PLANNING CONSULTATION RESPONSE

Application No	2025/0908
Proposal	Re-engineering and Restoration of Yew Tree Quarry through the importation of non hazardous Excavated Soil Materials.
Address	Stairfoot Brickworks, Wombwell Lane, Stairfoot, Barnsley, S70 3NS.
Date of Consultation Reply	02/04/2026
Consultee	Edward Jowett (Tree Officer)

Drawn: AH	Checked: HL	Approved: AH	
Project: UG1773	Scale @ A0: N/A	Date: 26/06/25	
Dwg No: UG_1773_ARB_TWS_01		Revision: 00

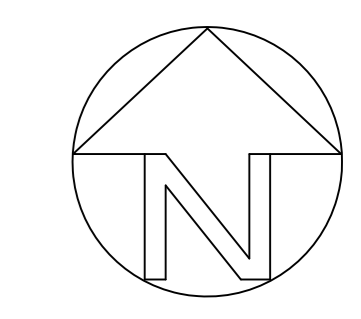
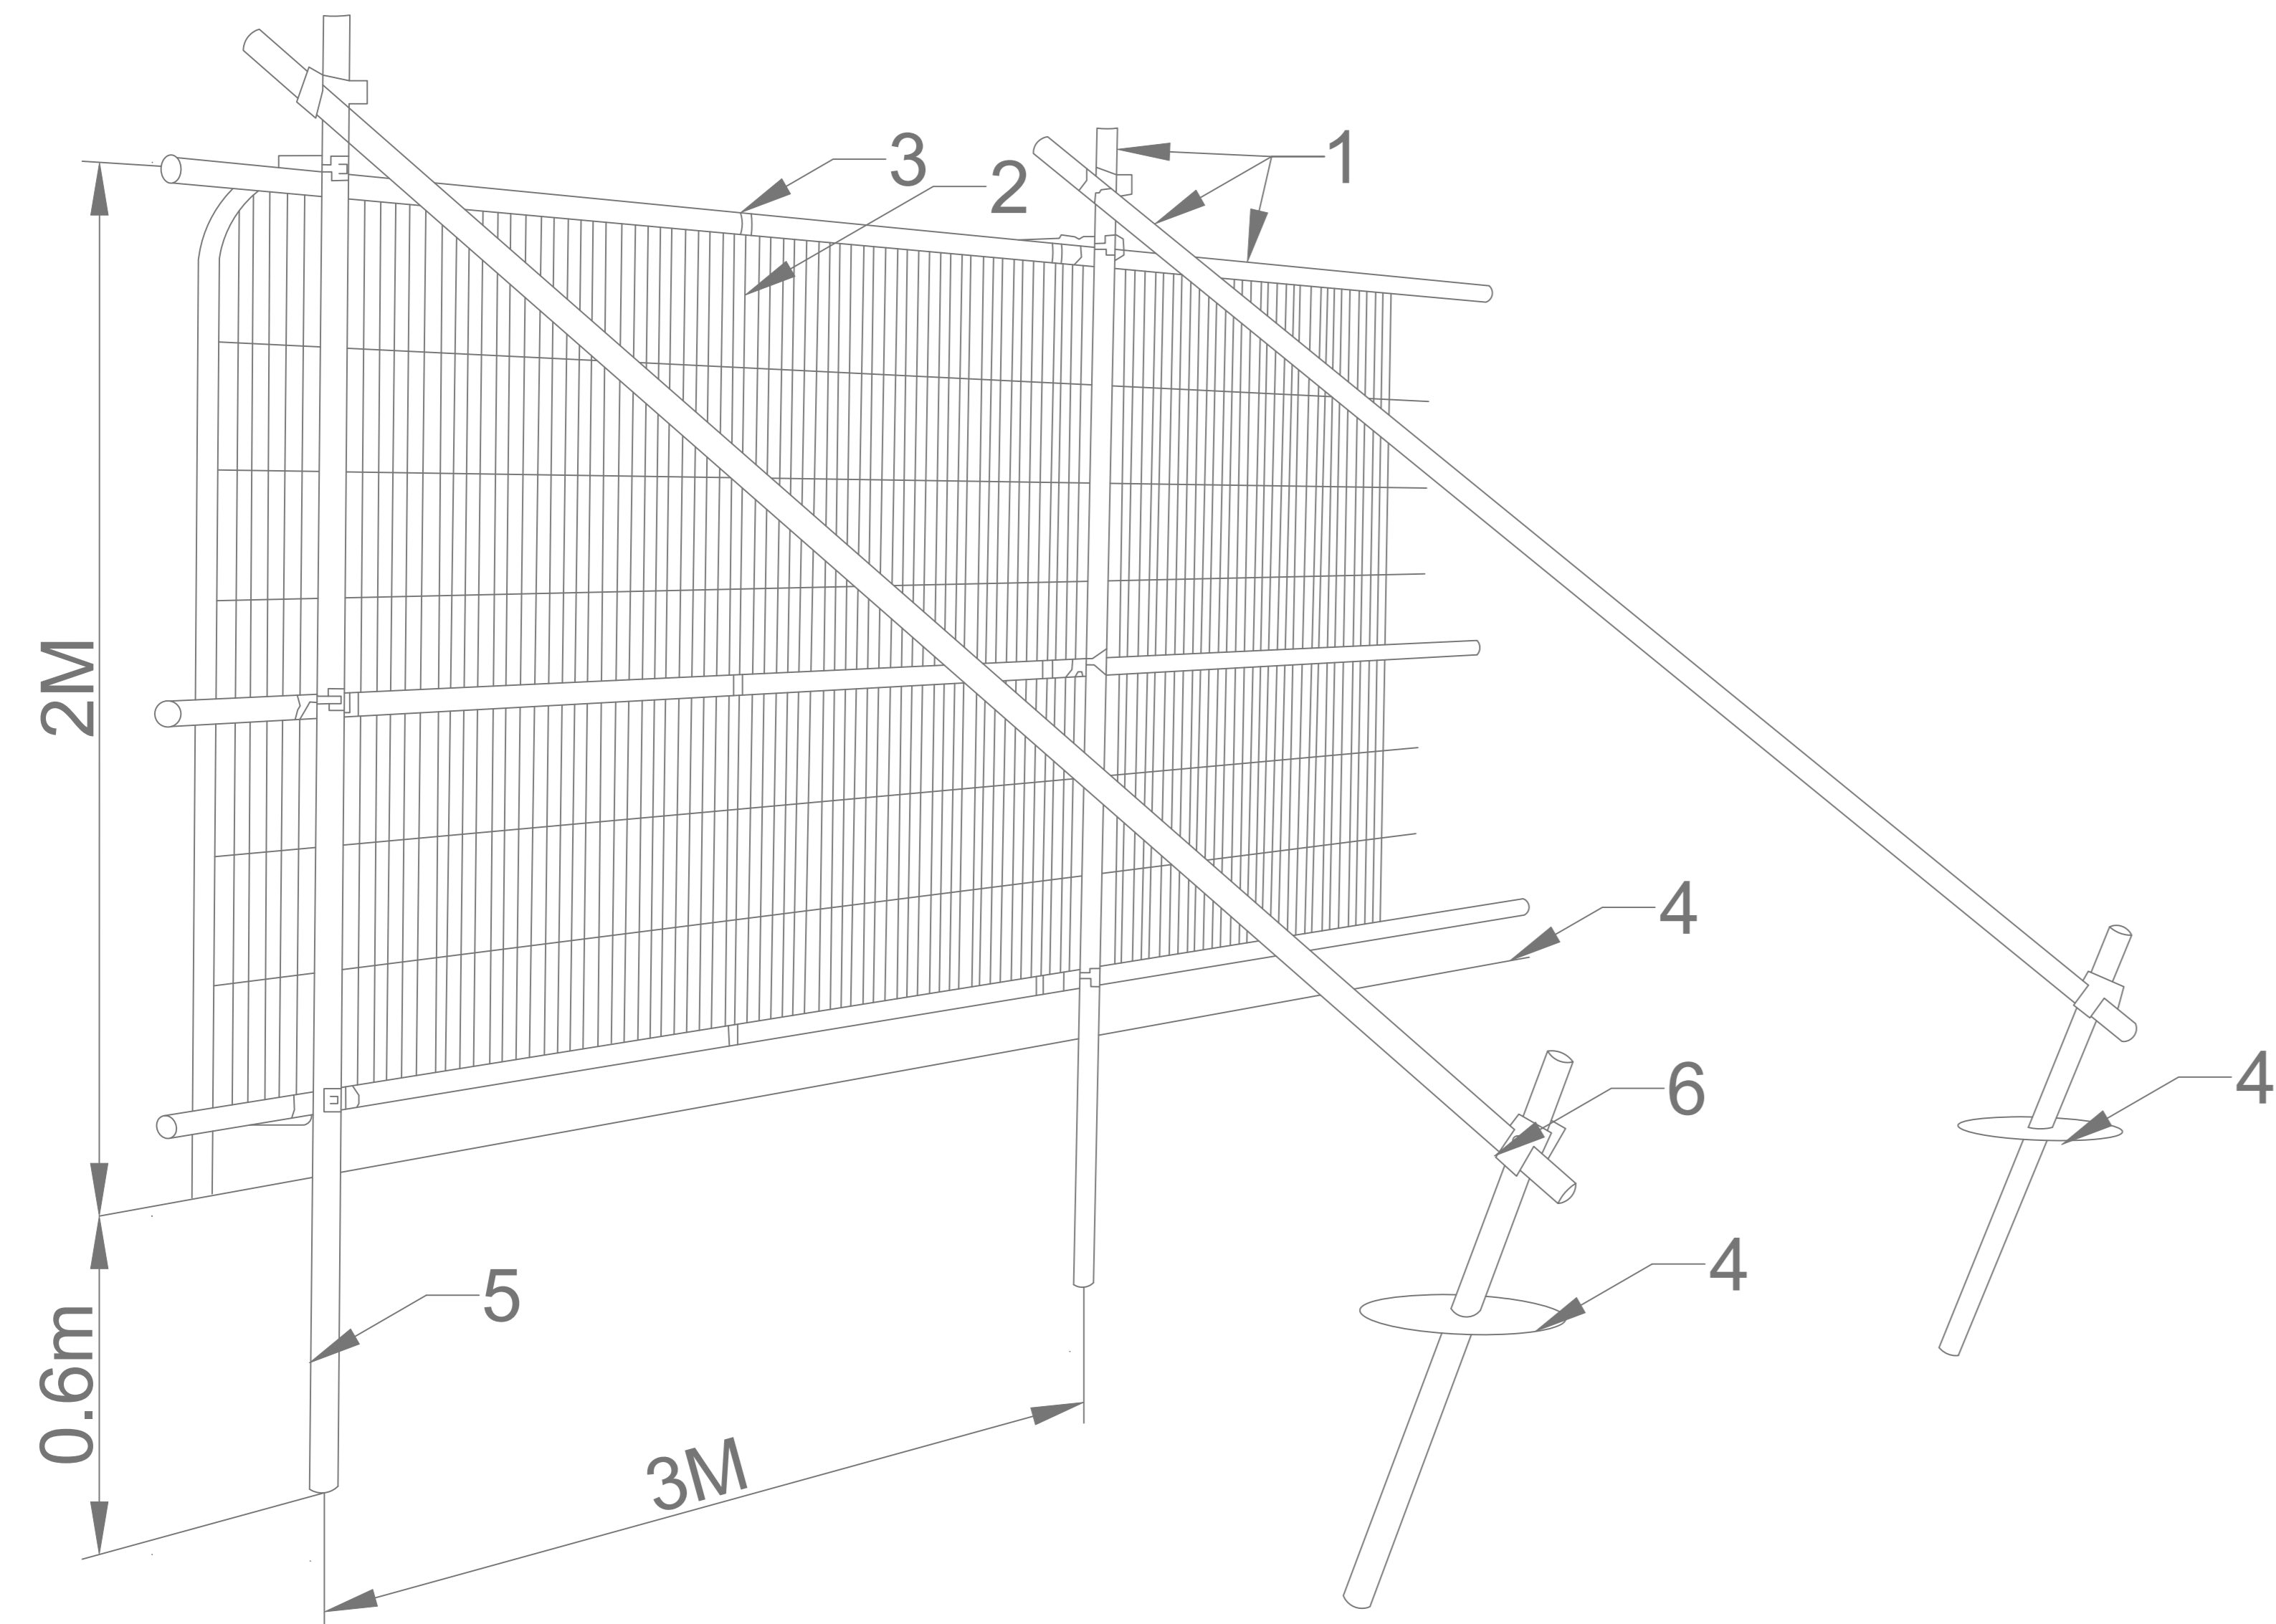
I have looked through the amended arboricultural information submitted with this application and have still have some concerns. The information I asked for as part of my previous response has not been looked at or dealt with as far as I can see. The additional information to deal with the impacts on retained trees has not been provided and nor has the more detailed survey works I requested to allow the retention and removals along the access route etc. to be properly quantified. The lack of detail in this regard means we do not know how many trees it is proposed to remove nor if any trees of particular value or merit are to be felled to facilitate the proposal. Likewise we do not know how those trees both on and off site on the edge of any of the proposed works which are shown to be retained would be impacted on by the proposal, including the trees protected by TPO 7/1973.

The level of information provided is currently inadequate in terms of the level of detail provided, the broad brush removals noted in the AIA are not fully quantified nor are the impacts on those trees it is proposed to retain looked at in any meaningful and useful way. I therefore still do not know how the proposed works will impact on the trees or to what extent.

I would therefore ask again that those trees to be removed be looked at more closely, be properly quantified in terms of the number of trees or area to be cleared and any larger more prominent specimens be identified and surveyed separately so their loss can be properly assessed and if deemed acceptable be properly compensated for. I would also ask that those trees within influencing distance of the edges of areas highlighted for tree removal be surveyed so the impacts upon them through level or surface changes etc. can be properly identified and dealt with as part of the AIA, including trees on the edge of the access and around the restoration and site cabin areas including any off site trees within influencing distance on the northern boundary.
